DECISION DELEGATED TO HEAD OF PLANNING
--

Application No:	H01-0805-24	Applicant:	Lincolnshire County Council
Proposal:	Proposed Vehicular Access		
Location:	1 Parkin Road (Access Off Barrier Bank) Cowbit Spalding		
Terminal Date:	20th December 2024

Title: Visibility Splays, 1 Parkin Road, Cowbit
Date: 18th November 2024
Scale: 1:500
Drawn By: SF

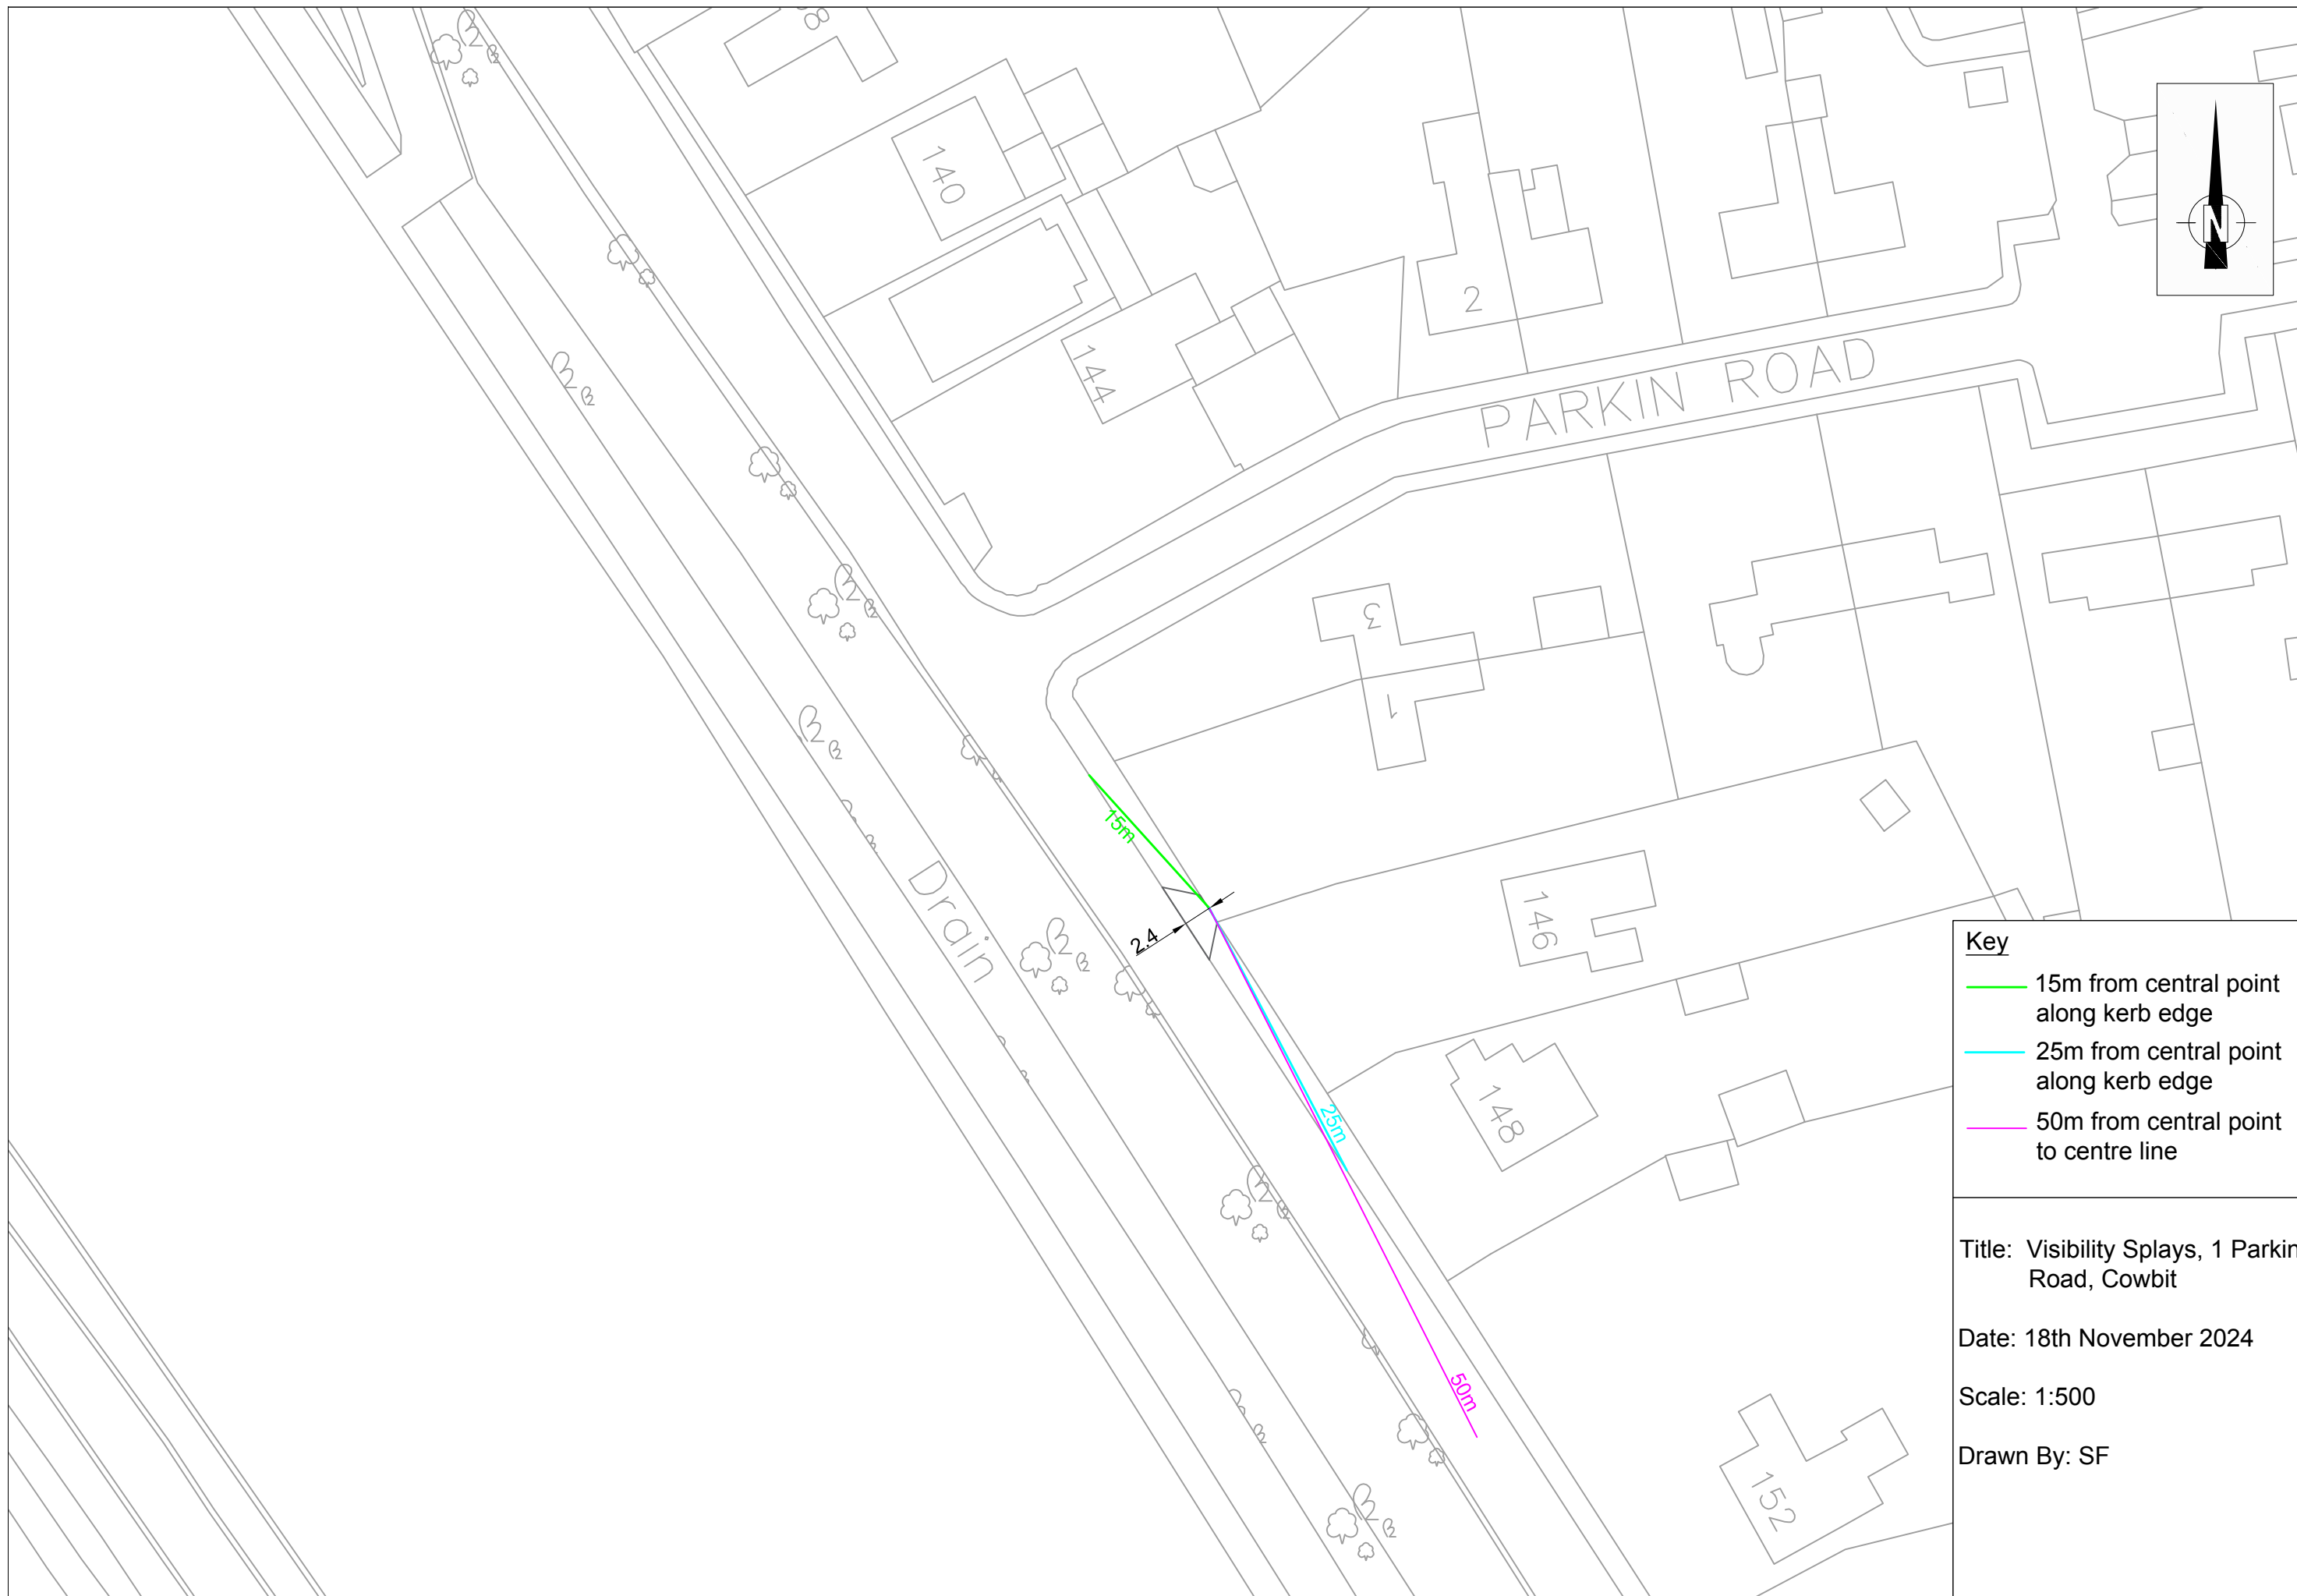
First Response (23 October 2024): Additional information is required. Visibility splays should be demonstrated in accordance with Manual for Streets. The width of the access needs to be detailed on the block plan.

Second Response (12 December 2024): Whilst the visibility is not in accordance with Manual for Streets vehicles will ease out with care. There are other properties in the vicinity with reduced visibility and there have been no recorded accidents along here. The proposal will not have an adverse impact on the public highway. A planning condition and an informative are recommended.
